From: Contact Centre (CRM) <contact@ribblevalley.gov.uk>
Sent: 09 February 2023 12:31
To: Planning
Subject: Planning Application Comments - 3/2023/0004 and 3/2023/0003 FS-Case-485500170

Planning Application Reference No.: 3/2023/0004 and 3/2023/0003

Address of Development: Pavement outside CJ's at 75-77 King Street, Whalley BB7 9SW.

DRAWING TITLE
**BT STREETHUB
CLT-205**

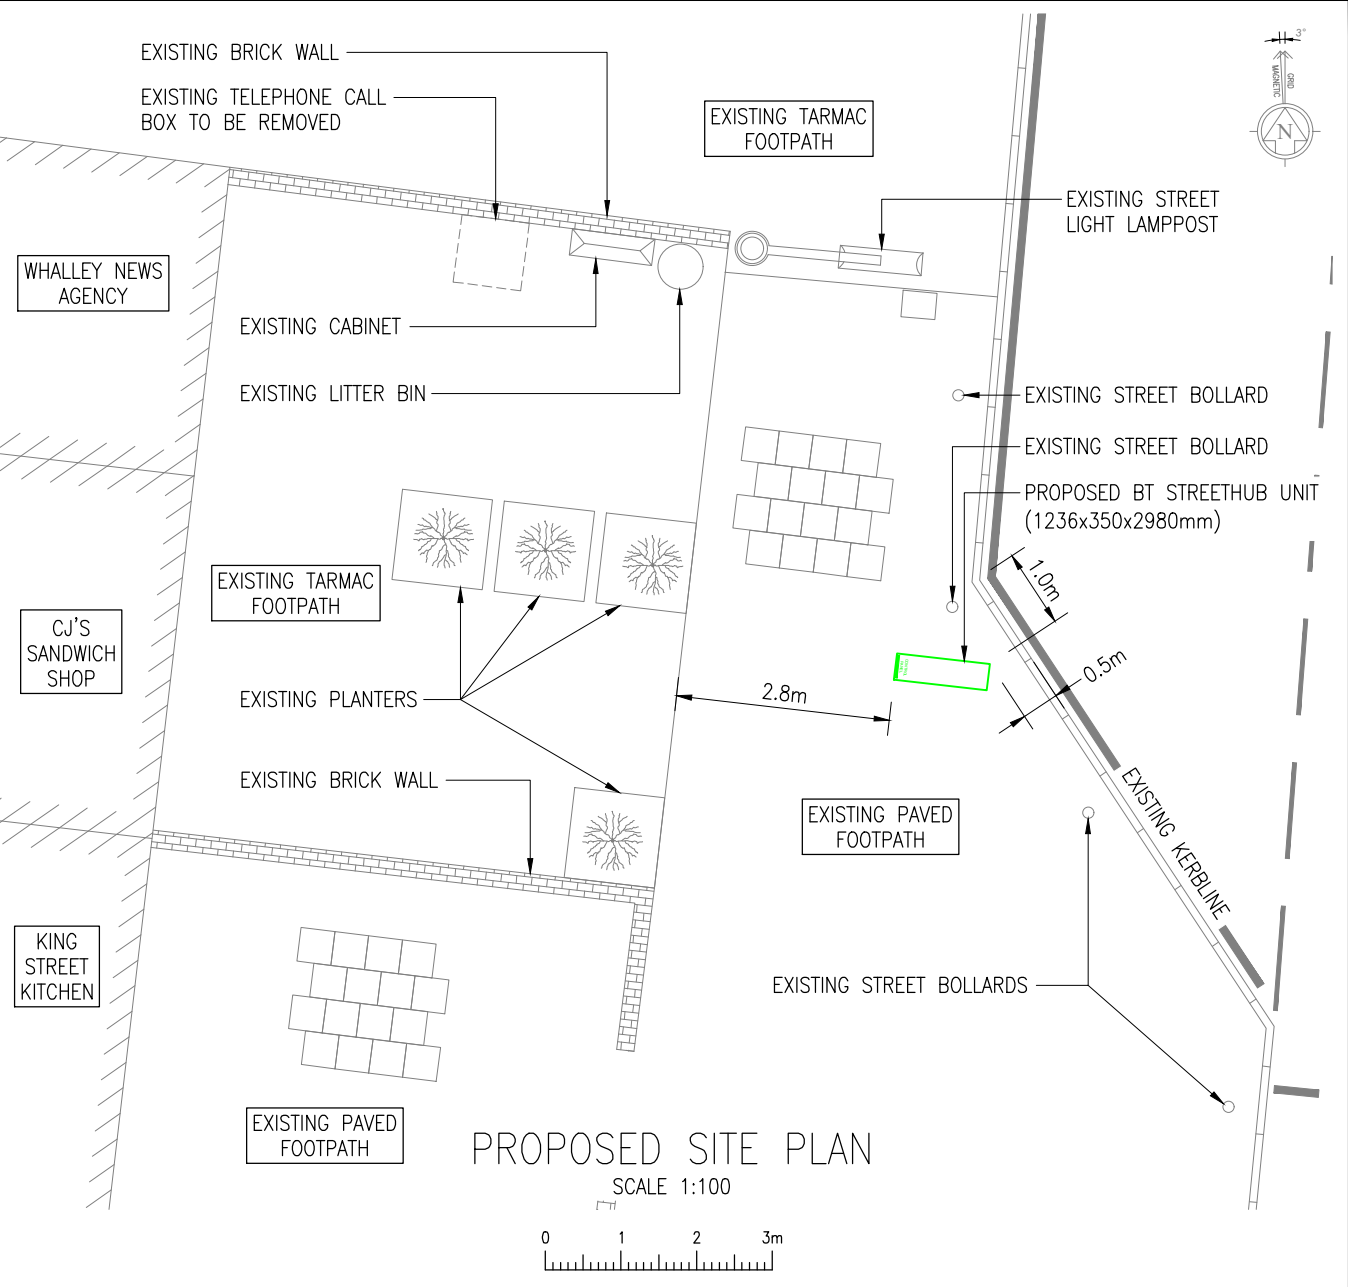
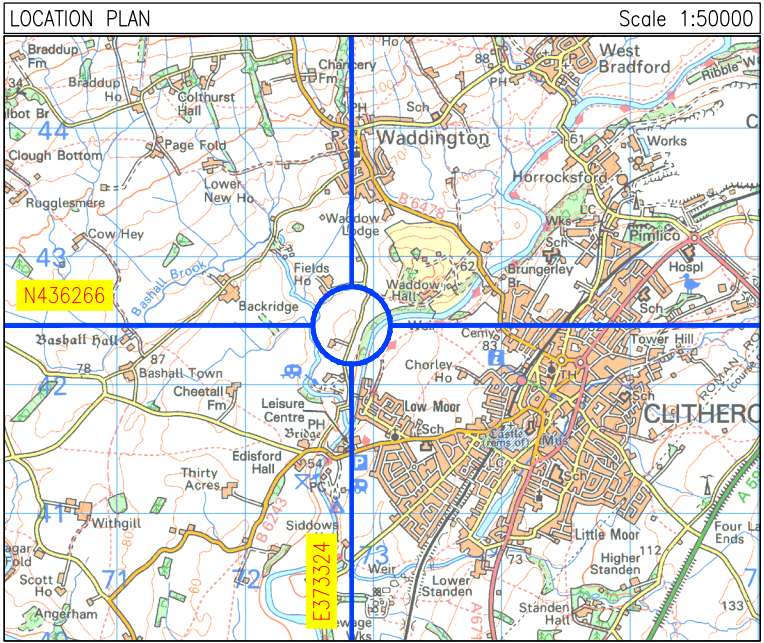
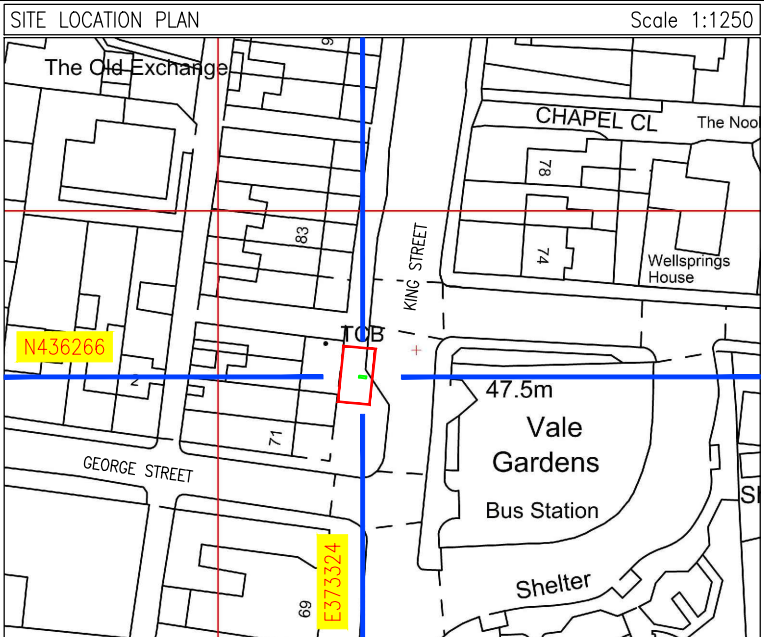
Comments: I write to oppose the installation of 2 large LCD screens on the pavements of King Street in Whalley.

The area is a conservation area with residents and businesses rightly restricted in their renovation of the area to maintain the heritage and traditional aesthetic of the village. Business are NOT ABLE to use back lit LED signs, therefore the LCD's would also breach these rules.

In 2022 the pavement was widened at extreme cost to the council and local businesses due to the disruption caused when the road had 4 way lights on it. This would completely remove the additional room that has been gained.

A large illuminated sign would add further distraction to drivers approaching the existing hazards in this particular area.

2/ The centre of Whalley is a conservation area and the signage is at odds with the character of the village.
